REQUEST FOR FURTHER INFORMATION - DONCASTER AVE MODIFICATION - SSD-9649-MOD-1

This letter has been prepared by Urbis on behalf of Next Constructions Pty Ltd (the Applicant) regarding the proposed modification to State Significant Development (SSD) Development Application for student accommodation located at 4-18 Doncaster Avenue, Kensington (SSD-9649-Mod-1).

Figure 2 – Approved and Proposed OSD Location

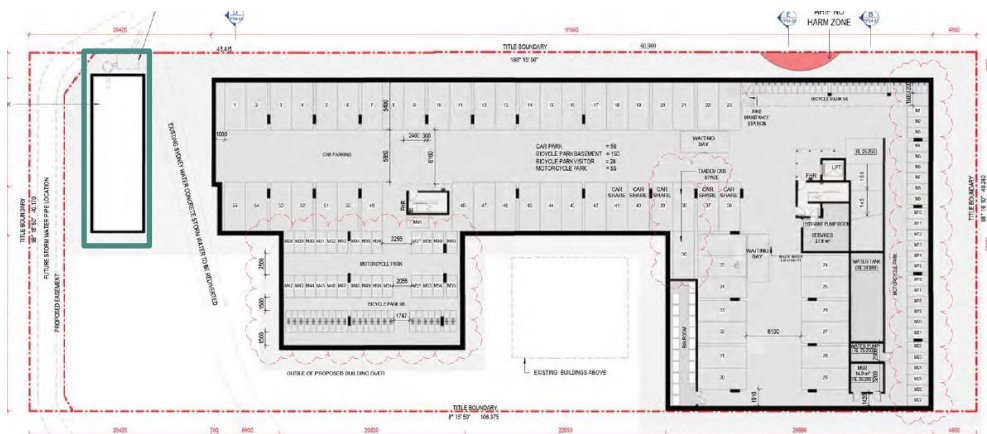
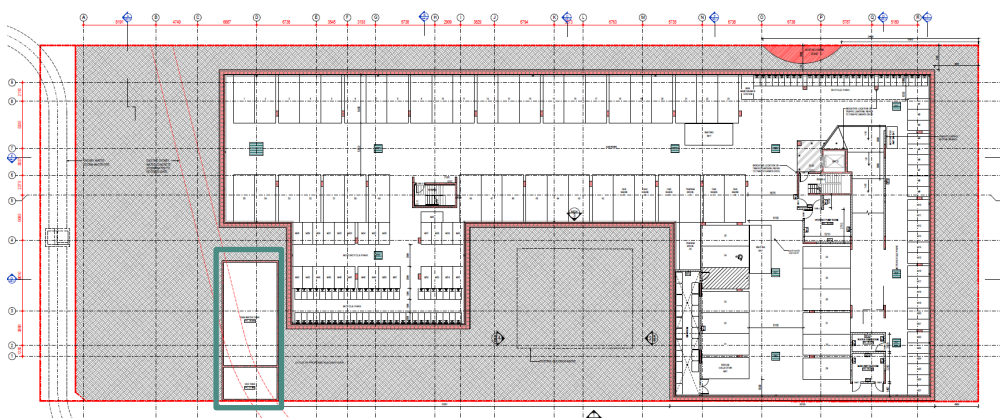
- Clarification, justification and assessment of any impacts for all proposed amendments to the basement.
- An updated basement plan clearly identifying all changes, e.g. clouded.

- If the approved rain water tank and OSD are being relocated
- If there are any proposed amendments to the existing Sydney Blue Gum within the front setback
- Confirmation that the BASIX Certificate has been updated to reflect latest plans

- All plans to show measurements (in millimetres), showing the 10m distance that will be provided between the centre of its trunk and this new 5m x 4m OSD tank;
- Update the Arboricultural Report to document the system that will be used for shoring up the exposed soil profile.
- Ensure that all of the other Tree Management Recommendations that are listed at Section 7 of the Arboricultural Report are incorporated as conditions into any consent.

The amended basement plan has no impact on the APZ and ongoing management of the Sydney Blue Gum (identified as Tree 42) within the front setback of the site. Additional measurements have been incorporated into the basement plan to ensure there is adequate separation between the tree and proposed OSD tank. The installation of a temporary aluminium trench box is also proposed prior to any excavation works is also proposed to mitigate any risks during construction.
